East Anglia ONE North and East Anglia TWO Offshore Windfarms

Applicants' Responses to Examining Authority's Written Questions

Volume 5 – 1.3 Compulsory Acquisition, Temporary Possession and Other Land or Rights Considerations

Date: 2nd November 2020

200

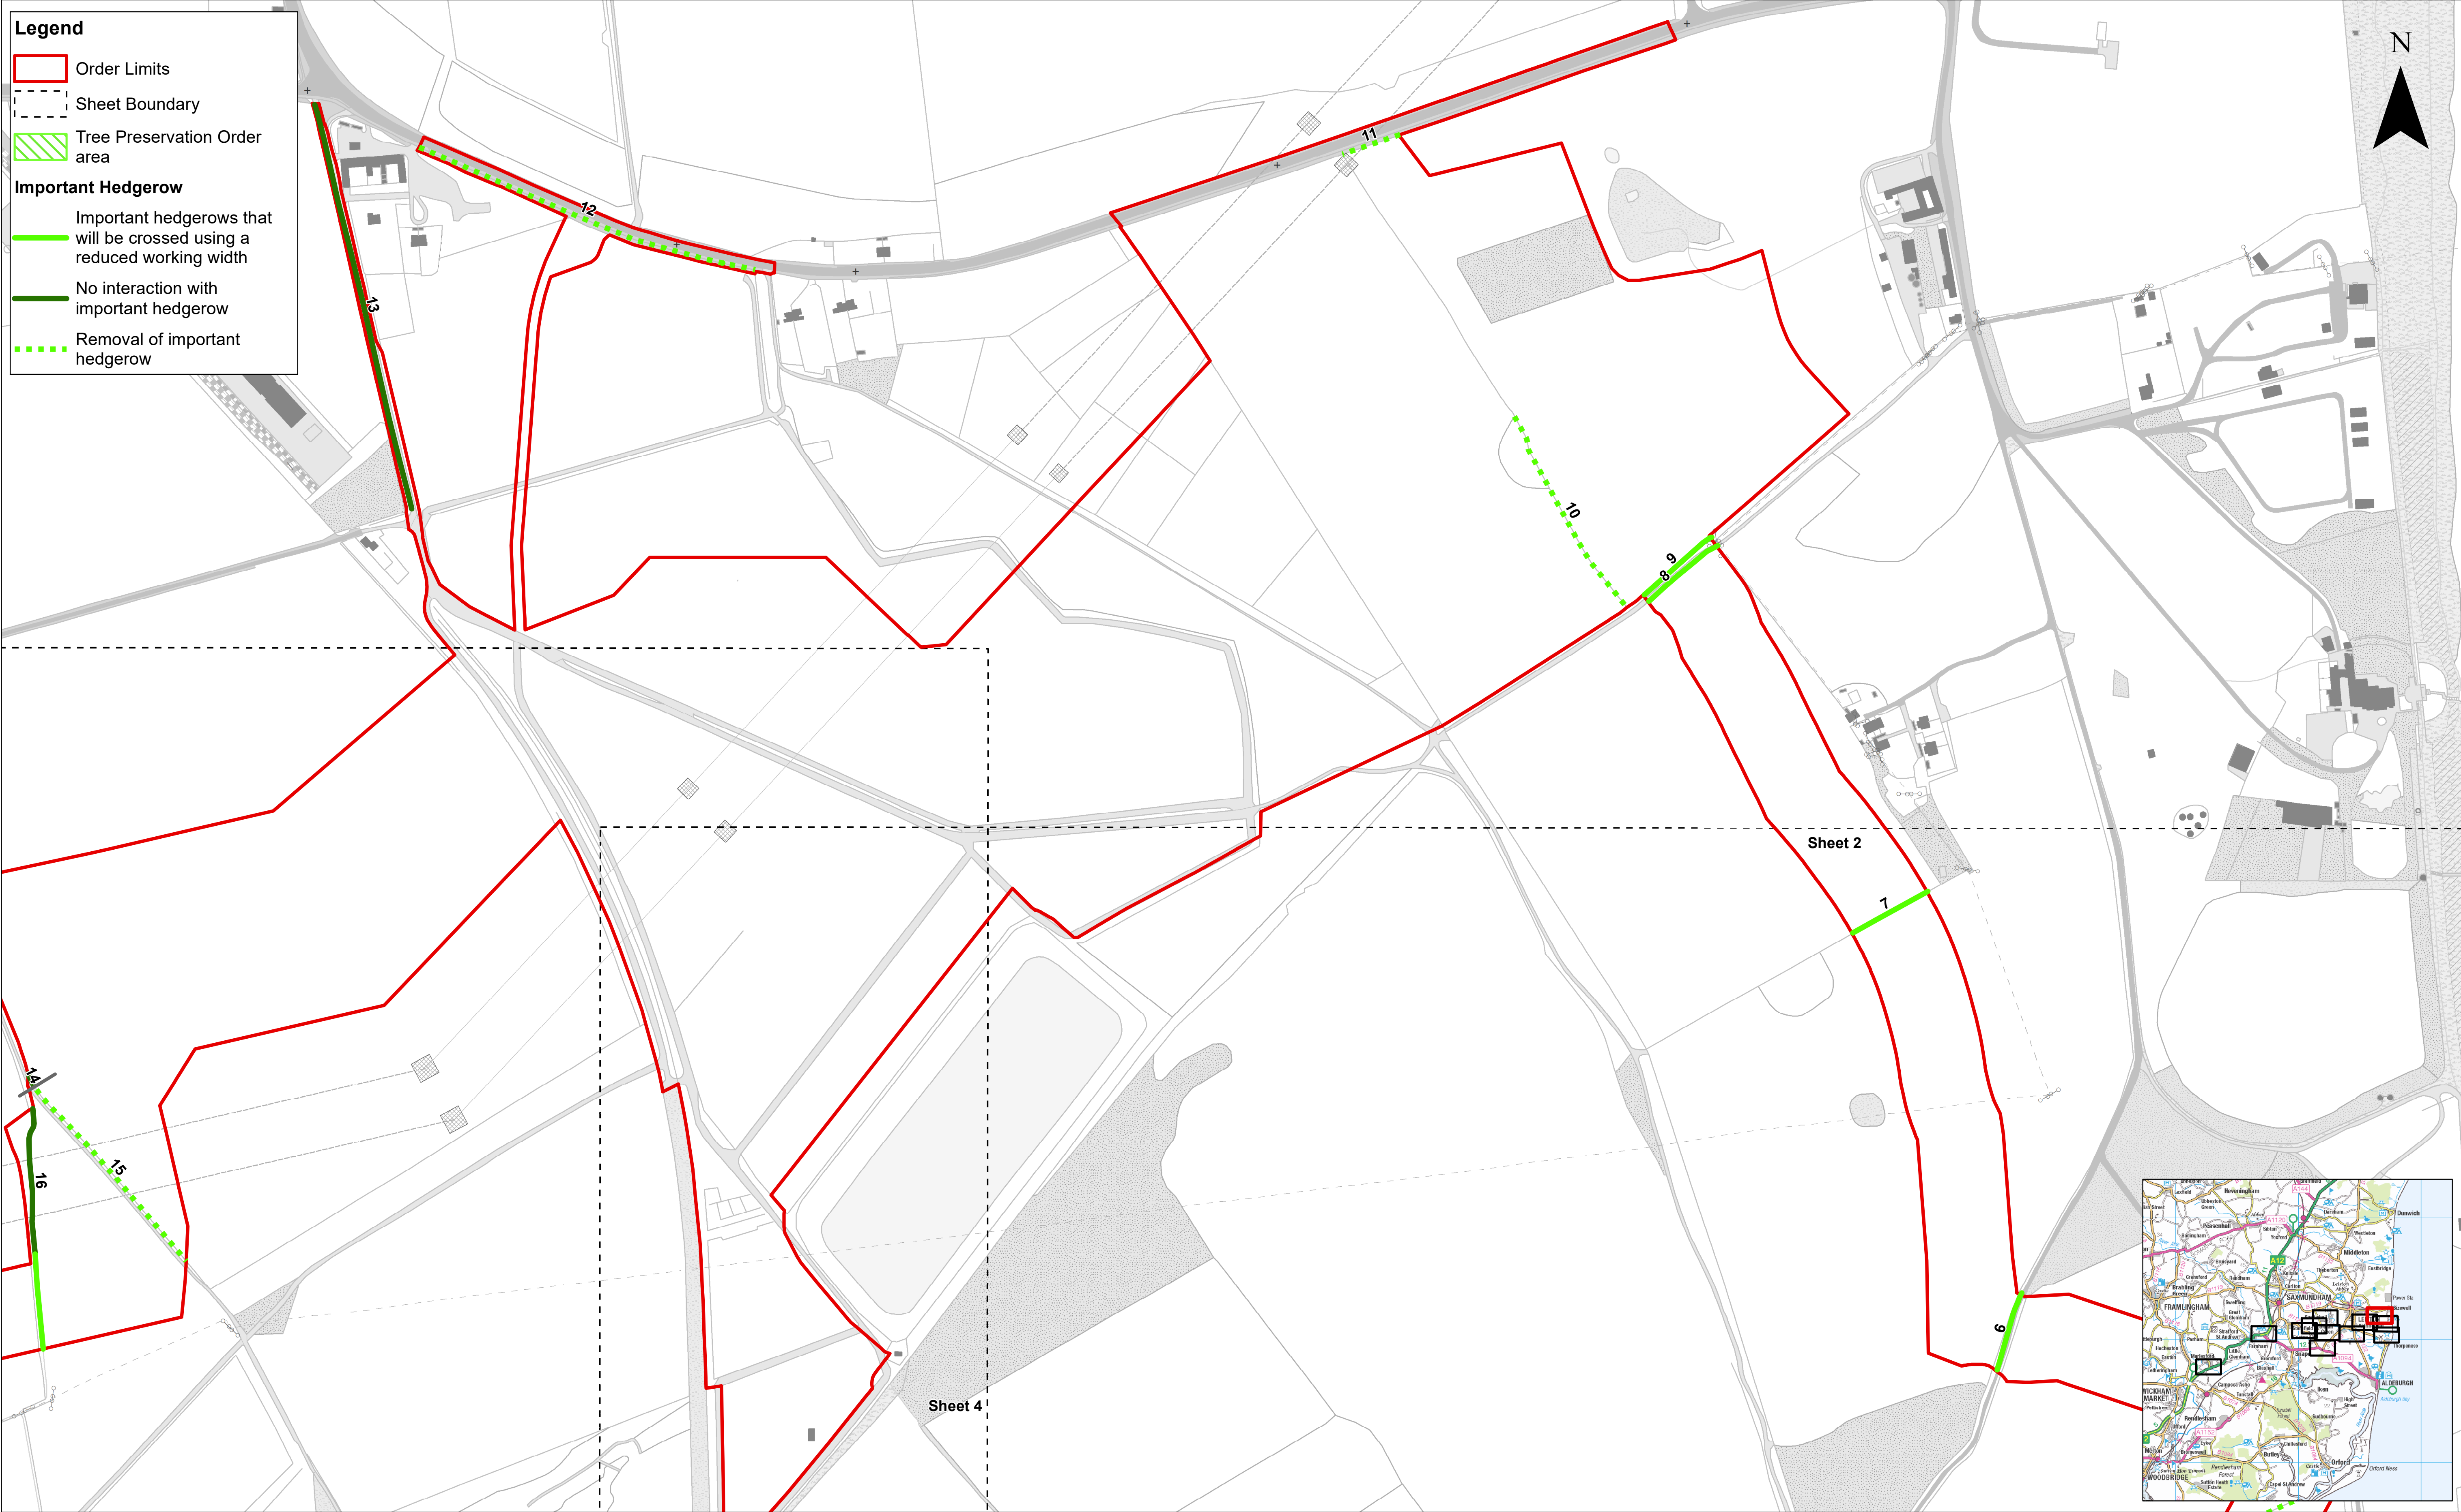
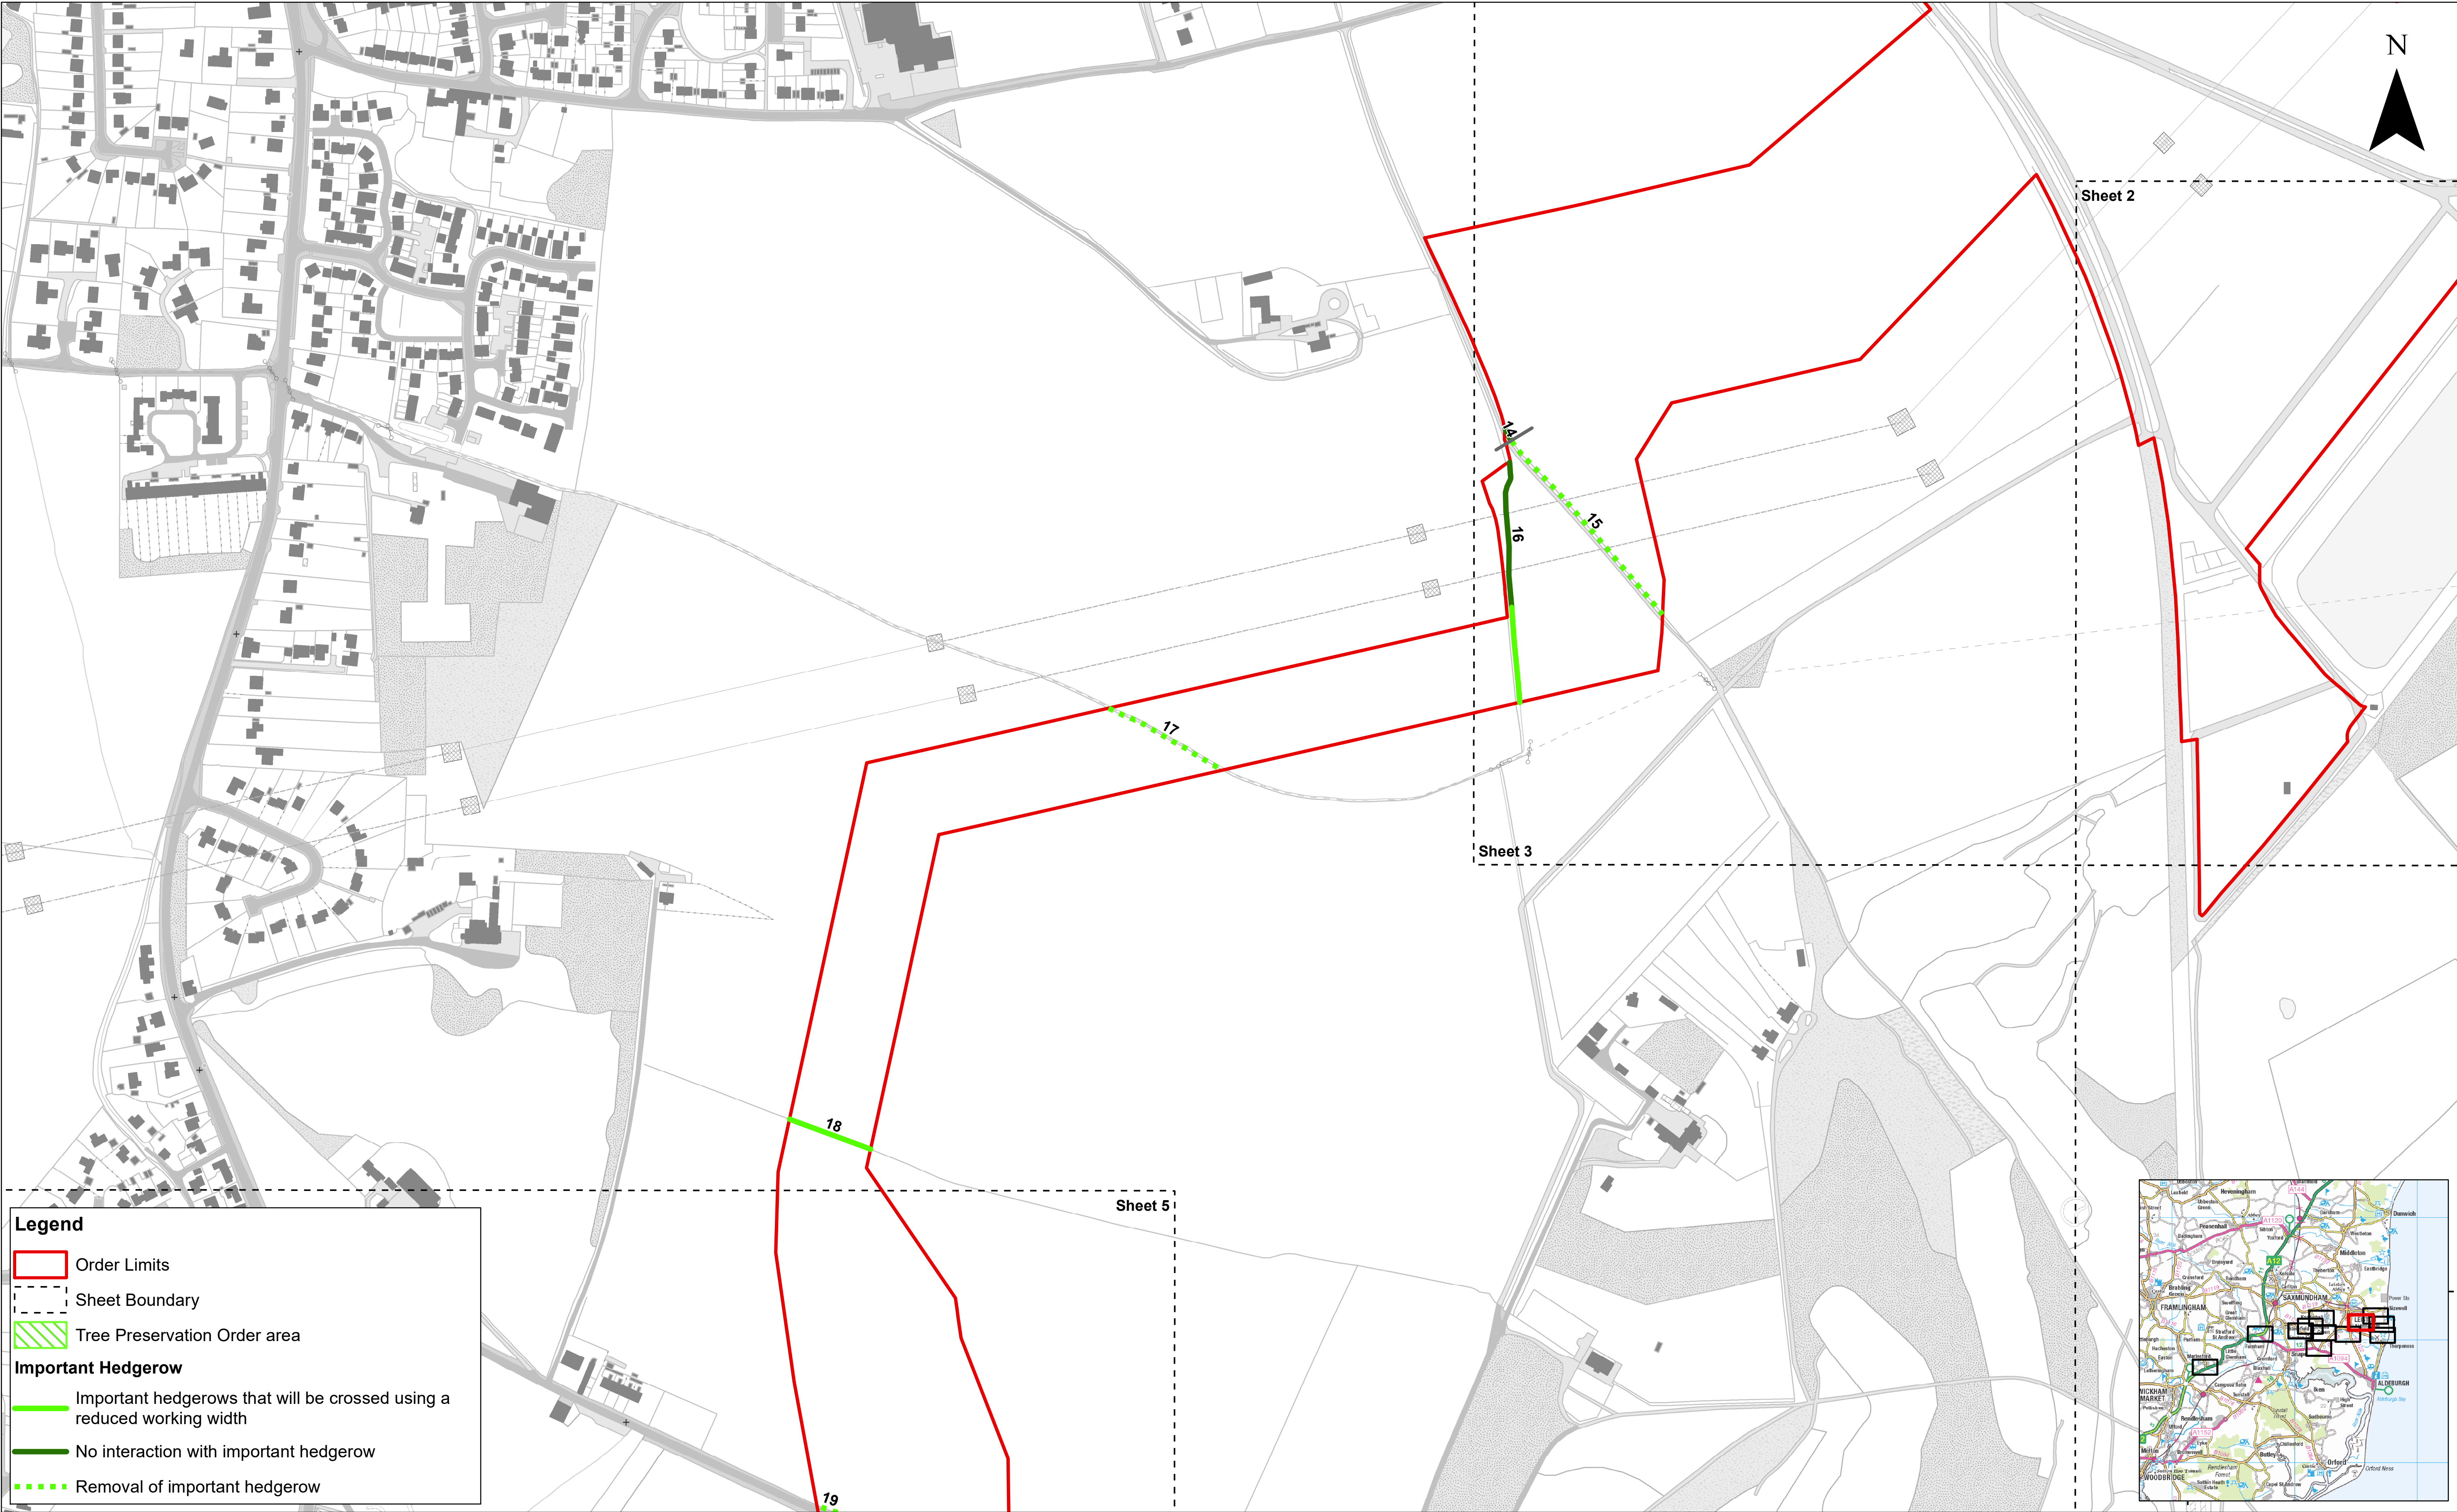
1.3.34	The Applicant	<p>1 2</p> <p>Schedule 11 part 2 lists important hedgerows that will be crossed using a reduced working width with reference to the important hedgerows and tree preservation order plan [APP-020].</p> <p>Please include in the crossing schedule and plan requested</p>	<p>This information is included in the Onshore Crossing Schedule which can be found in Appendix 7 of this document.</p>

ExA. Question Ref.	Question addressed to	ExA. Question	Applicants' Response
		elsewhere in this question set details of important hedgerows crossed, specifying the necessary width and the crossing method to be used in each case.
